## **RMG Response Letter to—Development Plan and Final Plat for Northcrest Flex Space PPR**

**PCD File No.: PPR-21-036**

### **Fifth Review Letter**

Subject: Northcrest Flex Space  
2510 and 2522 Canada Drive  
Colorado Springs, CO 80922

ENG:	DOV	
DRAWN:	TPT	
CHECKED:	DOV	
DATE:	08/12/2022	
#	REVISION	DATE
JOB NO.:	180649	
SHEET NO.:	C-03	
	of 12

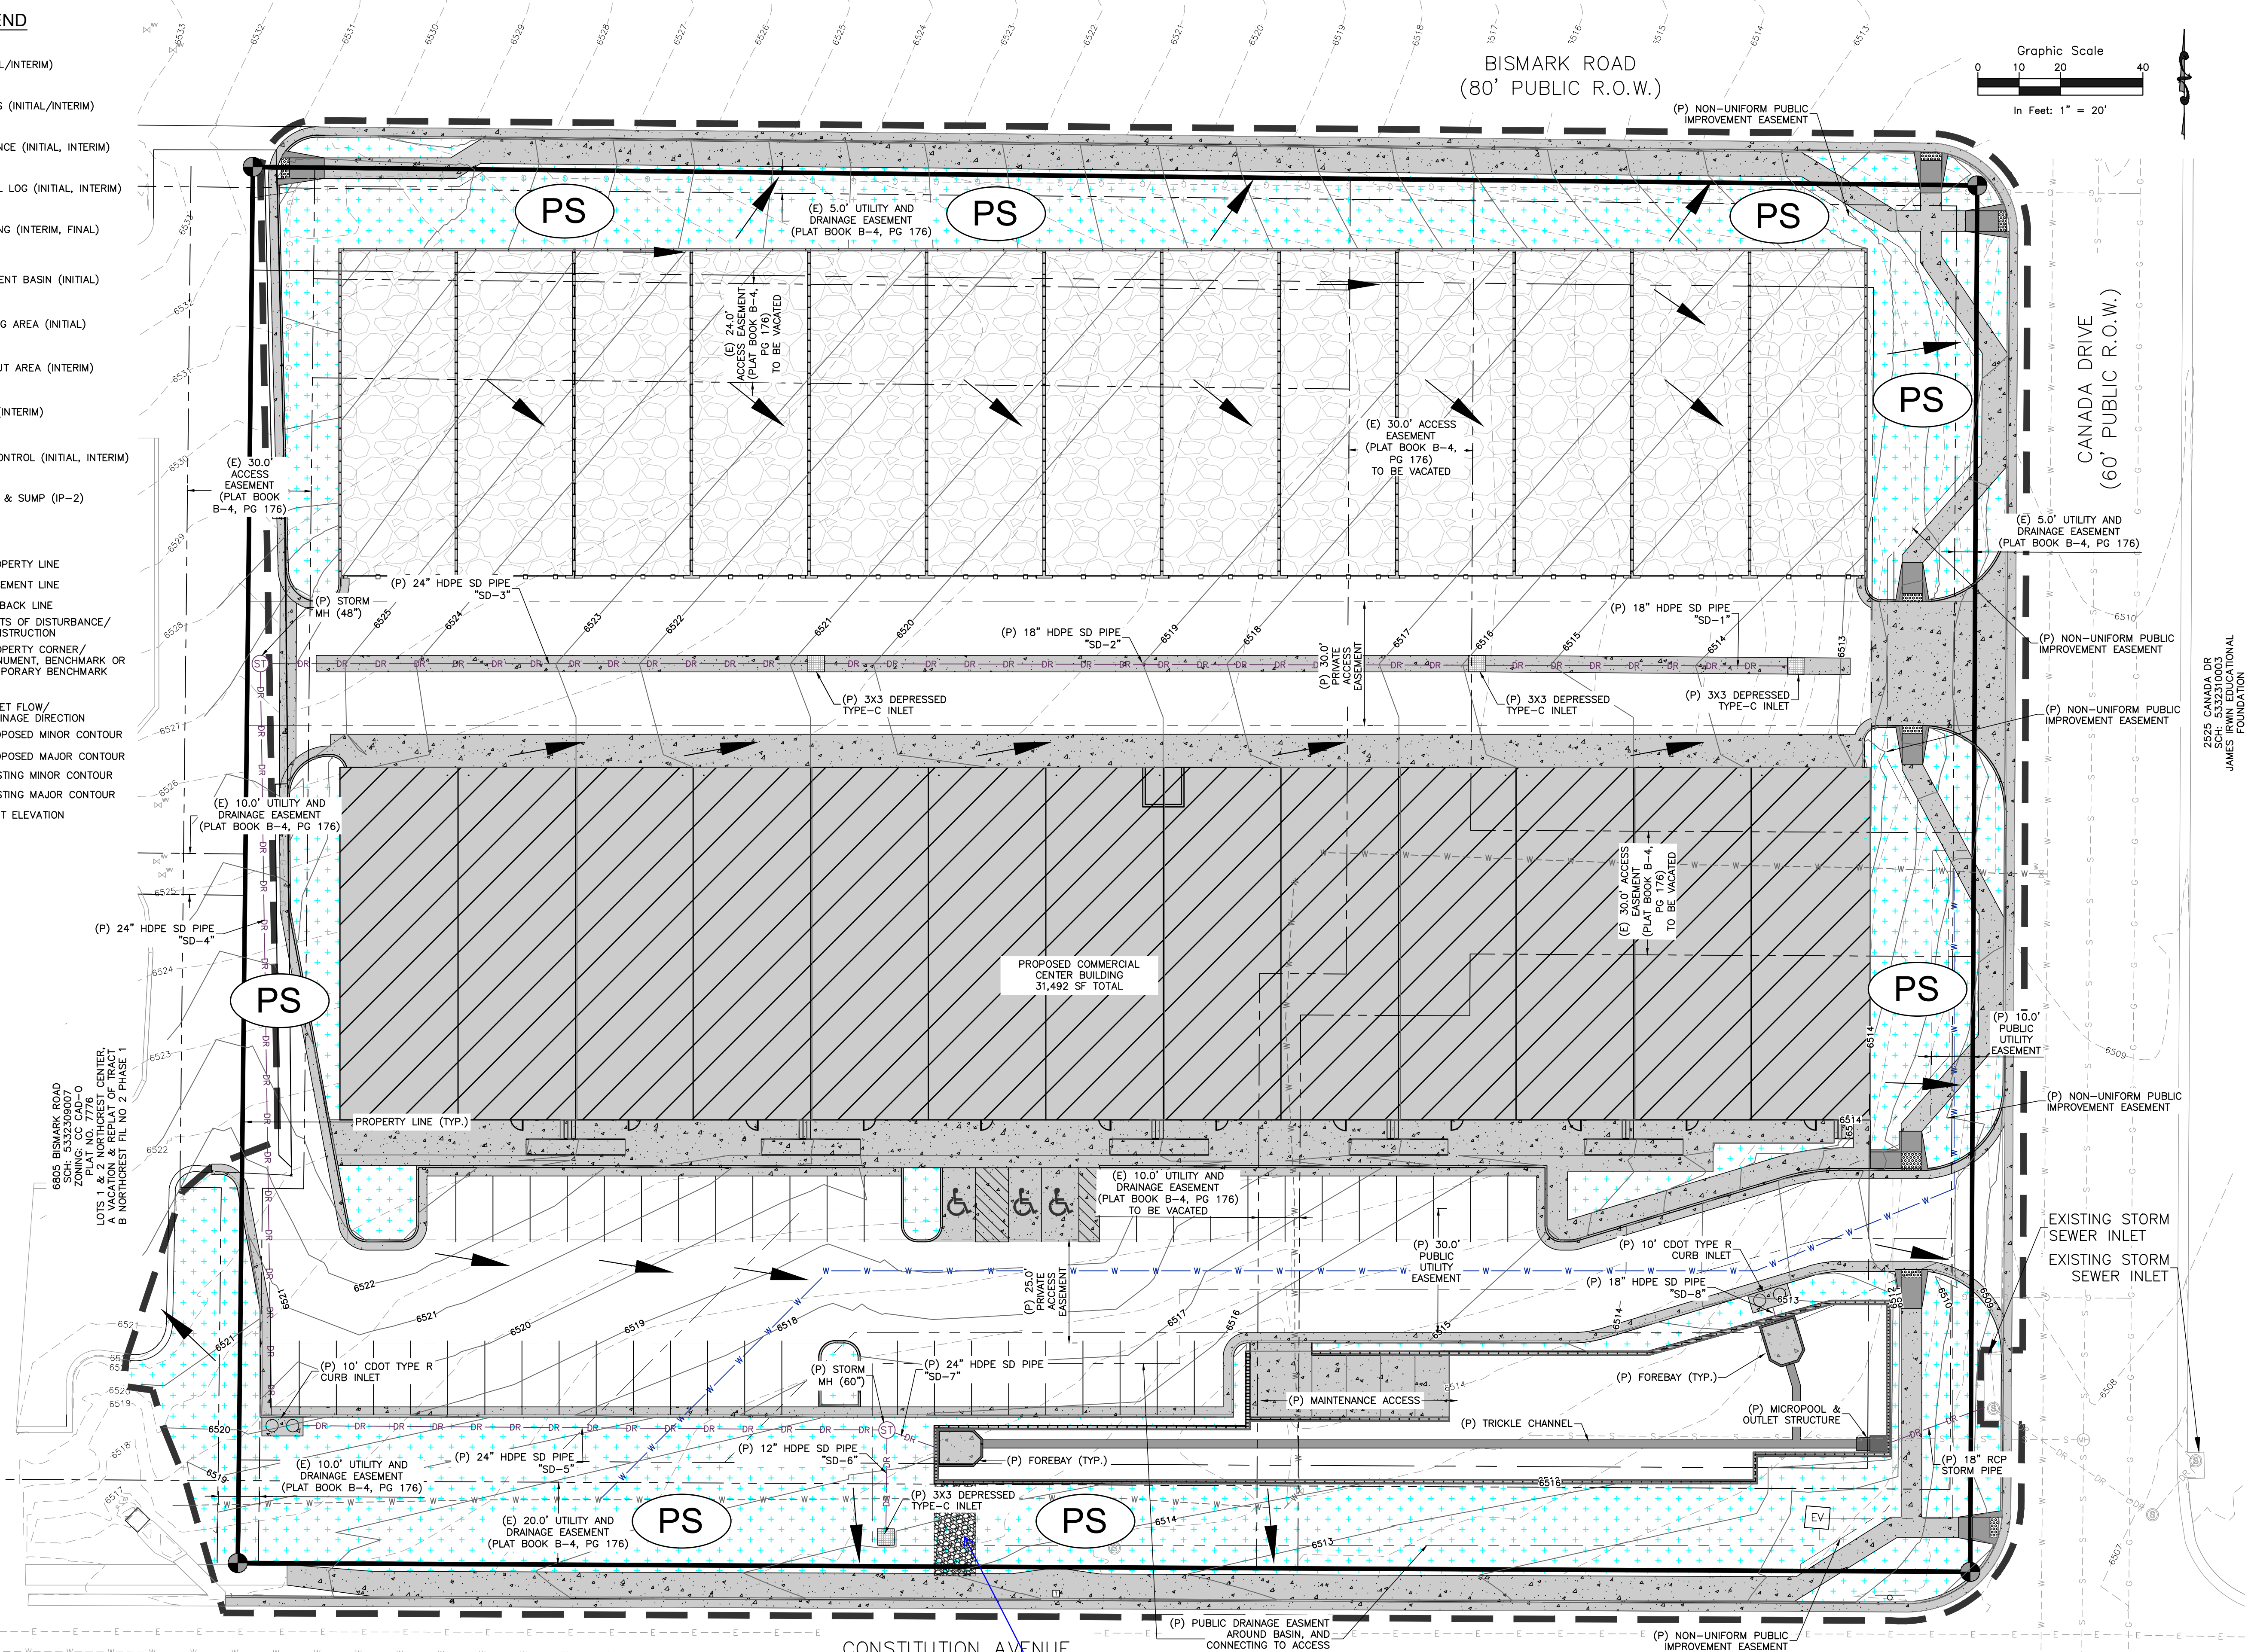
2. It doesn't seem like existing Site constraint would require vertical walls on all 4 sides of the pond. Consider extending the pond and sloping the sides where allowable to better meet WQ treatment standards.

3. Show retaining wall drains and detail.

**RMG: After meeting with the county, vertical walls are required due to site constraints.**

**RMG: Please reference the structural plan set for these details.**

ENG:	DWG	
DRAWN:	TPT	
CHECKED:	DWG	
DATE:	08/12/2022	
#	REVISION	DATE
JOB NO.:	180649	
SHEET NO.:	C-04	
	of 12

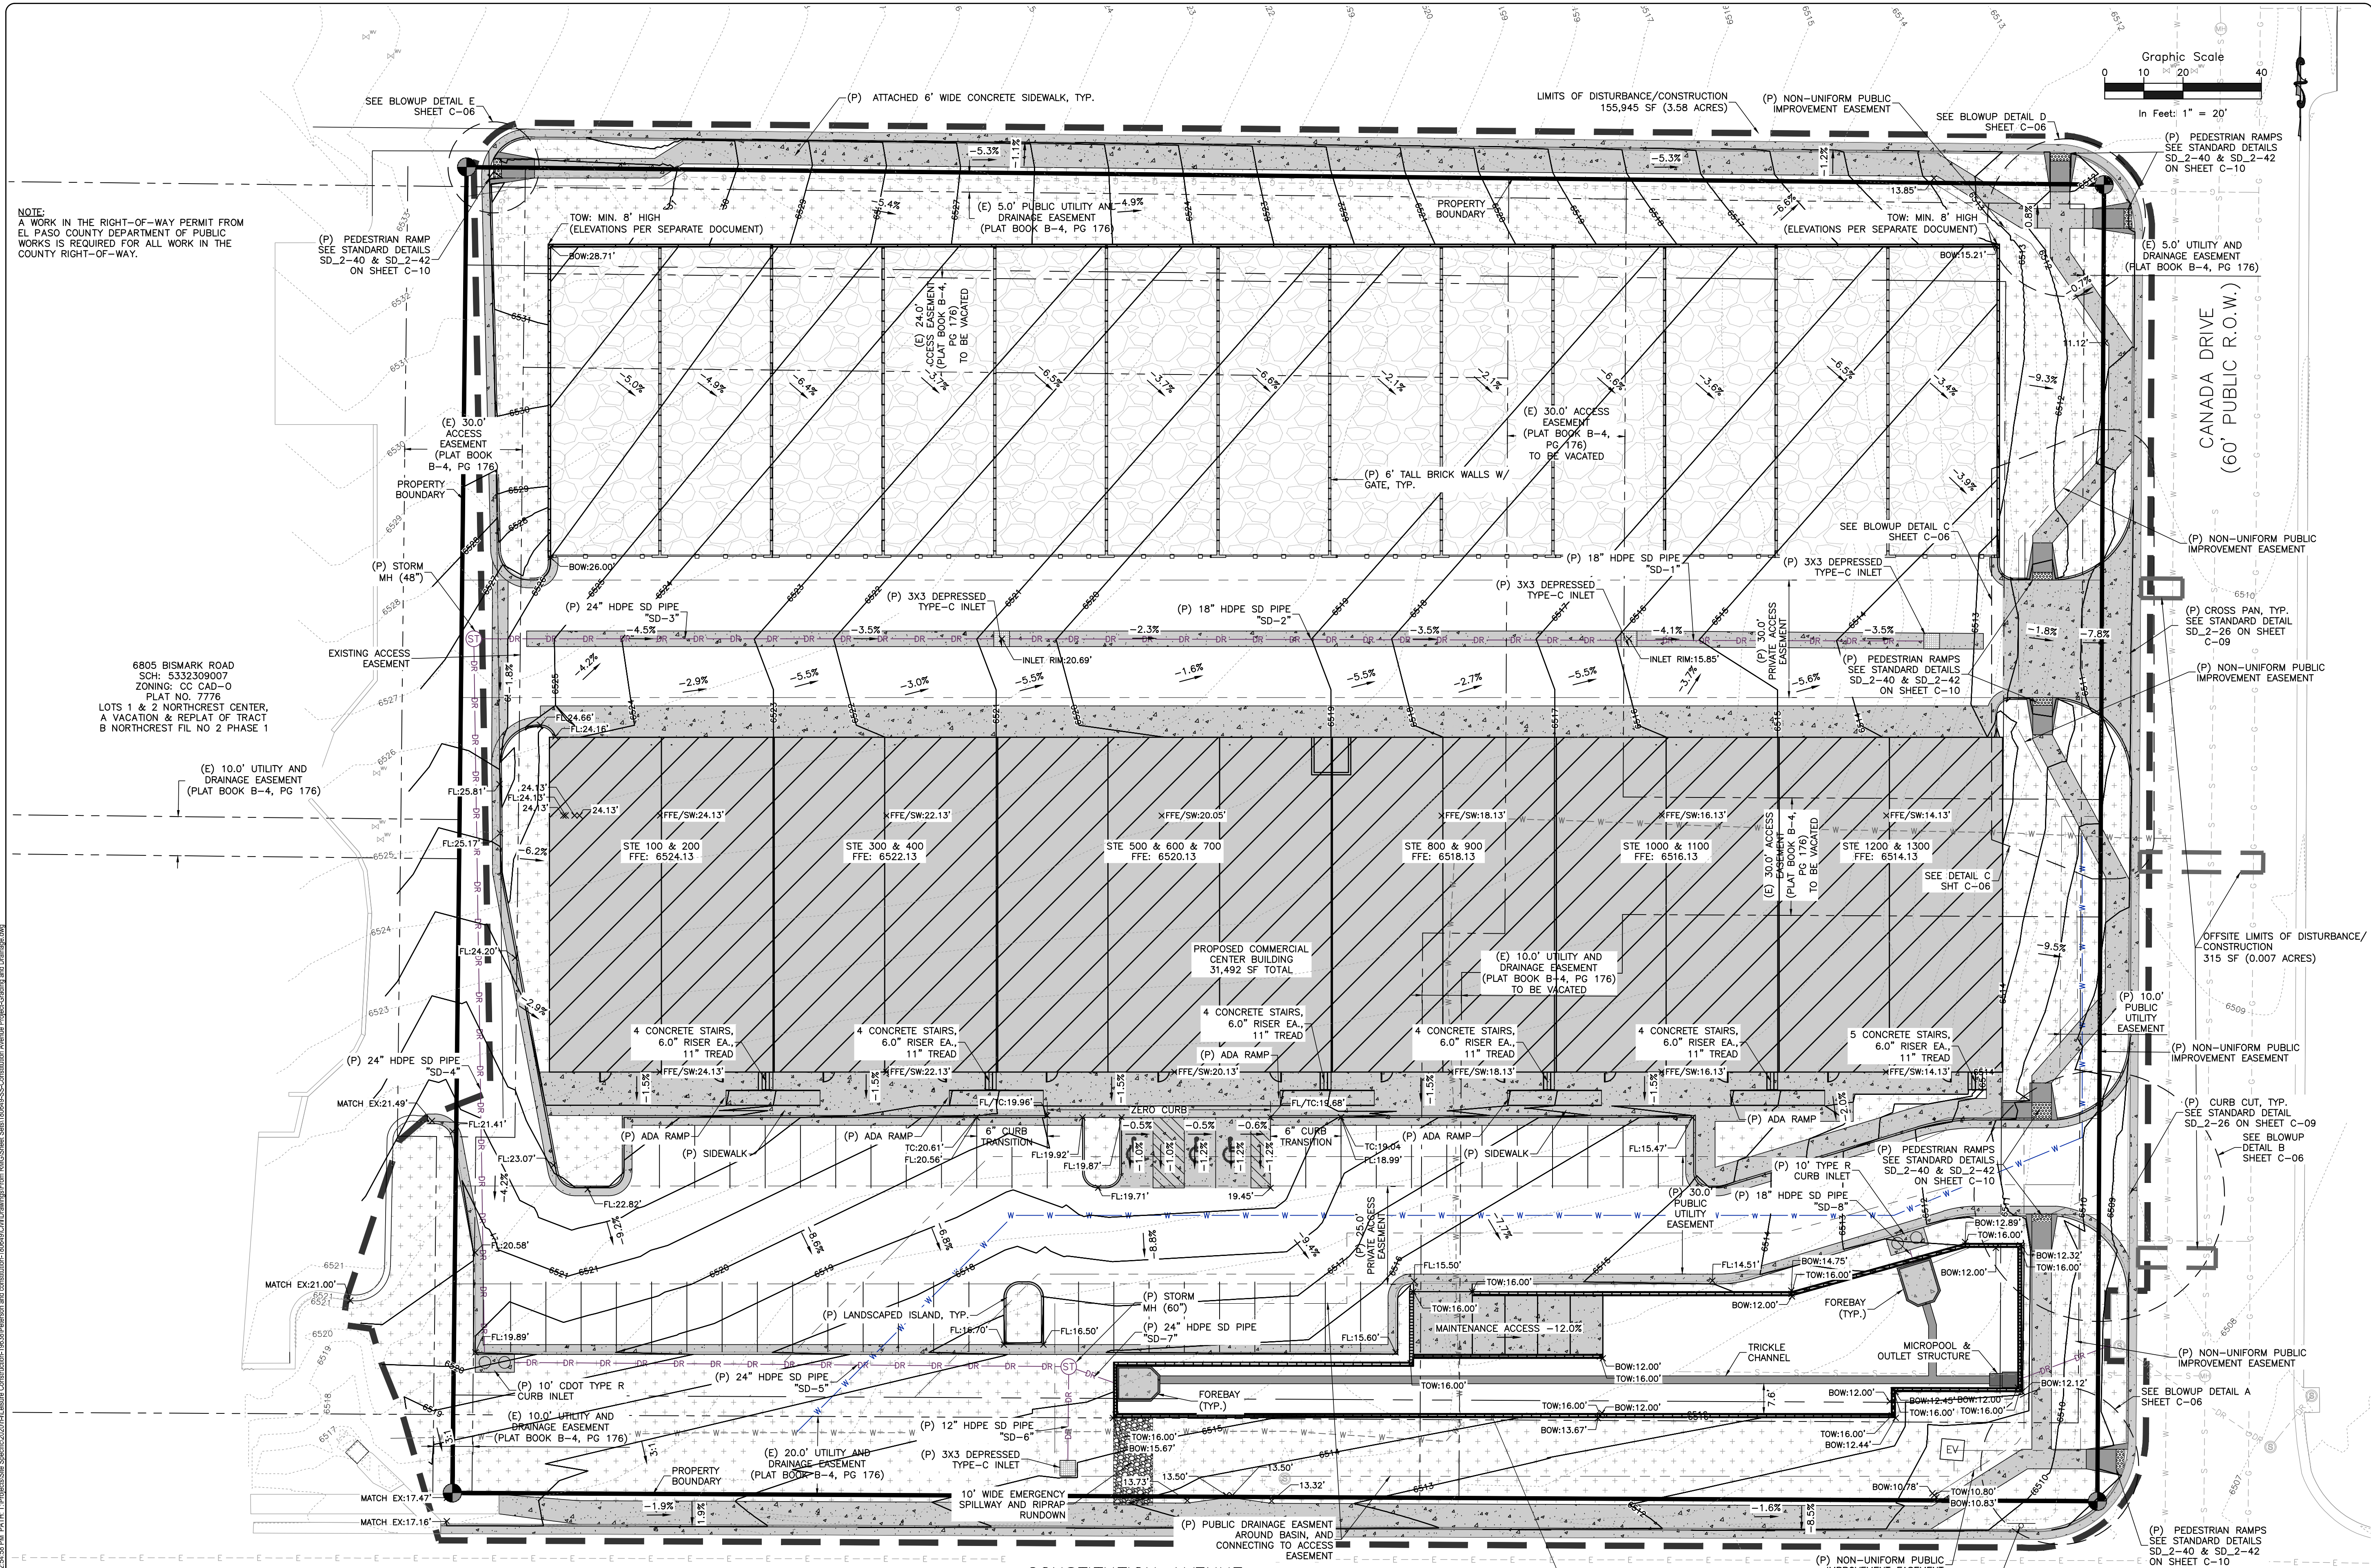
4. Please label this hatching. If this is rip rap please show the type and dimensions per DCM Vol. 1 Chapter 10.10 Table 10-7.

**RMG: This has been labeled.**

ENG:	DOV	
DRAWN:	TPT	
CHECKED:	DOV	
DATE:	08/12/2022	
#	REVISION	DATE
JOB NO.:	180649	
SHEET NO.:	C-06

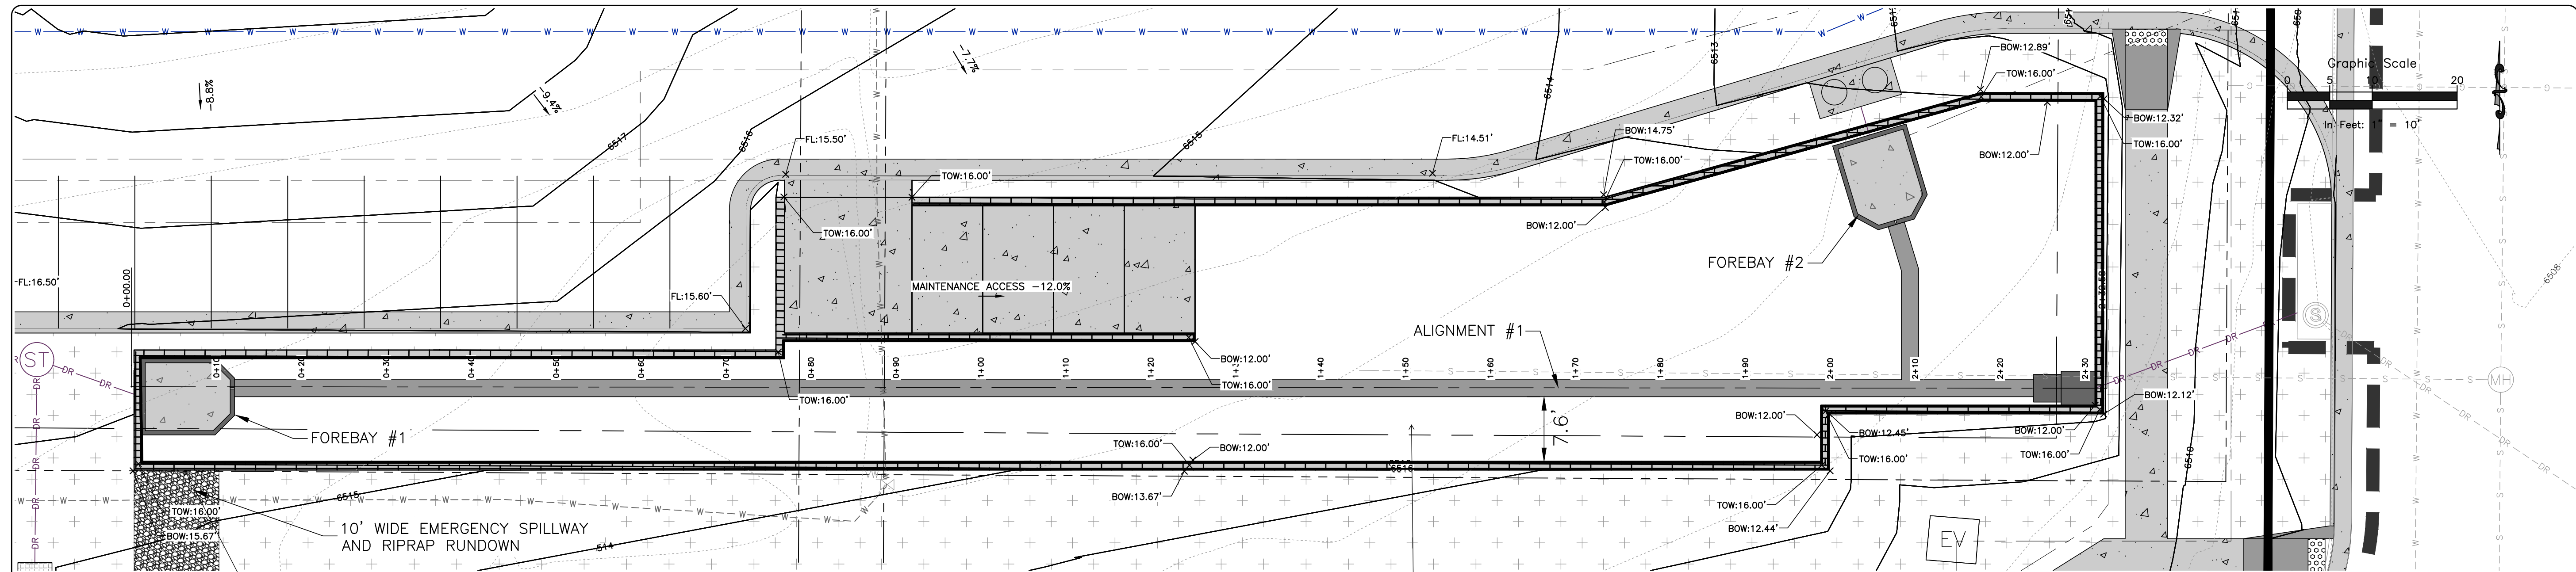
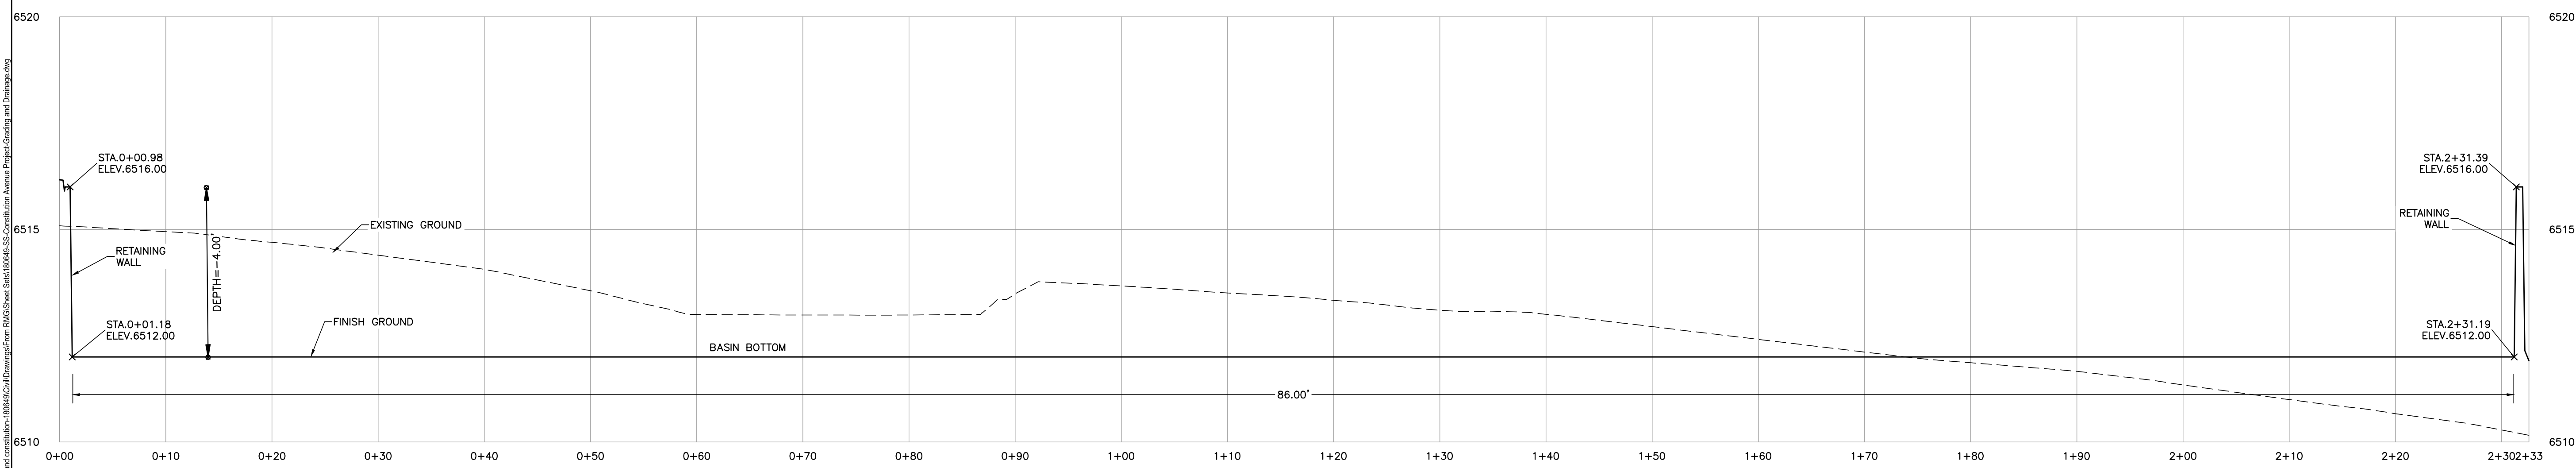
5. Provide detail, including wall cut, tie in to existing grade, riprap type and size.

6. Show all pond bottom slopes towards trickle channel and outlet structure.

**RMG: These details for the pond have been included.**

**RMG: The pond grading has been revised to slope towards the trickle channel and then down to the outlet structure.**
